Marge Schmuckal - 39 Exeter St - 051-E-019

From: Marge Schmuckal
To: tbraun@usm.maine.edu
Date: 8/19/2013 3:08 PM
Subject: 39 Exeter St - 051-E-019

**A 101**

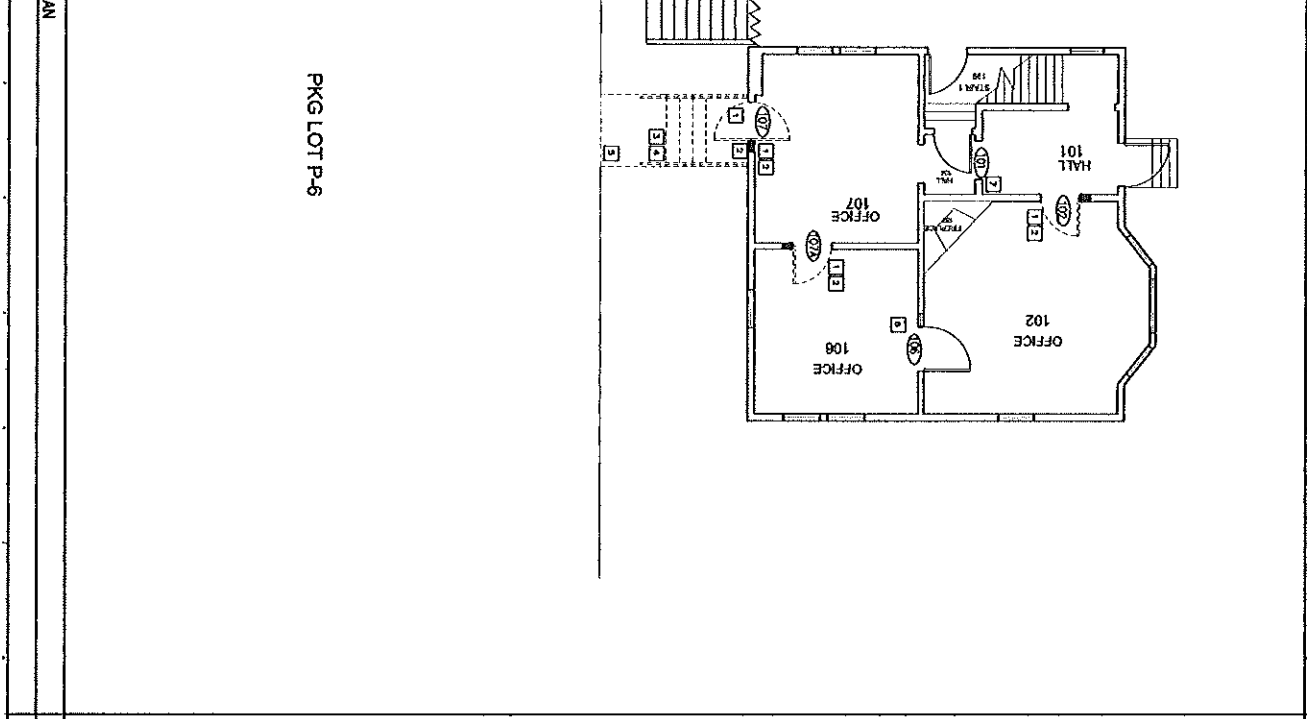
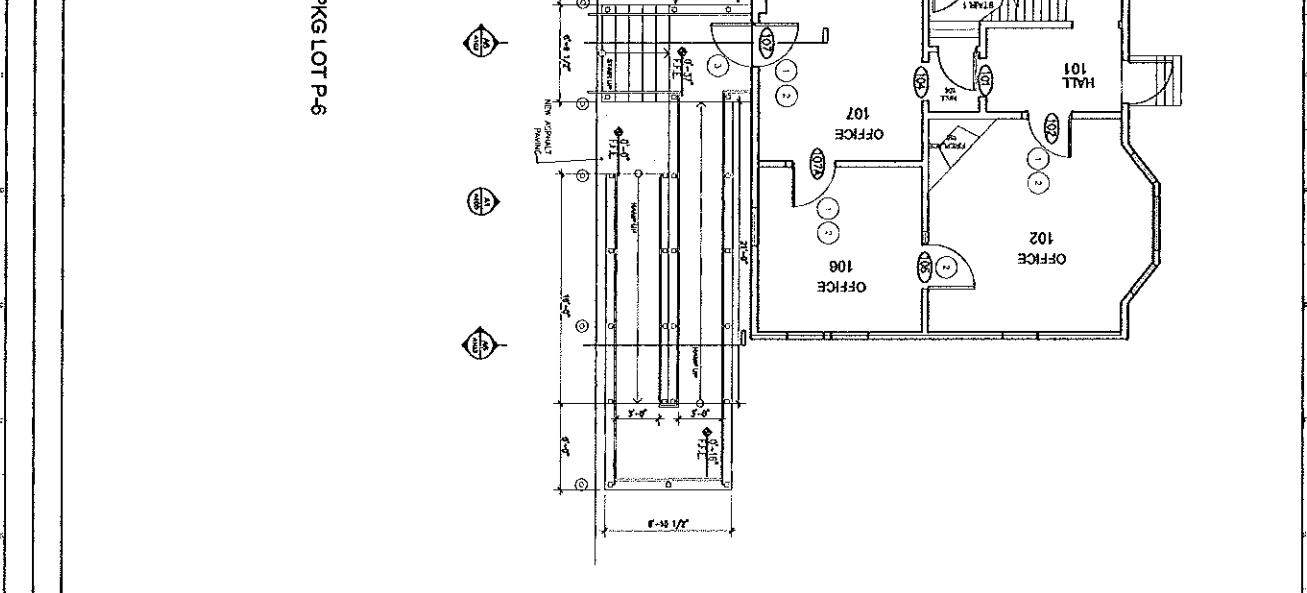
Your plot plan submission does not have any setbacks on it. What is the side setback for the new structure that abuts the private property that USM does not own? I do need that setback before I can sign off on your application. The overlay zone requires that side setback to be met.
